Planning Application Ref: FG/113/20/T

Location: 2 Phoenix House, Ferring Grange Gardens, Ferring, BN12 5HU

Description of works: Crown lift to 3m 1No. sweet chestnut tree

T1 SWEET CHESTNUT

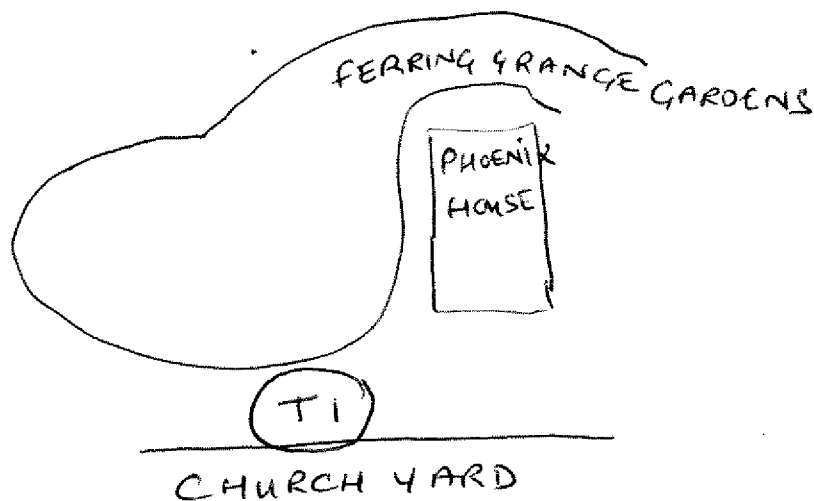
- I have had to consider this application by means of a desktop review, using the information and plans submitted as well as online resources.
- The applicant seeks to provide 3metres overhead clearance on all aspects, which ought to remove/reduce only small diameter branches – so of limited consequence to tree health and form.
- It is located adjacent the churchyard site and so is both visible from surrounding properties and to those attending the church/cemetery. As such, it has public amenity value.

- The work proposed is justified on arboricultural grounds. This is a prominent tree which provides visual amenity and is to be carefully pruned to maintain reasonable enjoyment of residential property and with respect for natural tree form.
- There should be no loss of public amenity on completion of the proposed works.

- I recommend **CONSENT** for this application, subject to the following condition:

- Part a) Where whole branches are to be removed and final cuts made close to the trunk or branch union they are to be made as shown in Figure 2 of BS3998:2010
- Part b) Where branches are to be shortened back the final cuts are to be made at the correct angle shown in BS3998:2010 and adjacent to a live bud or lateral.
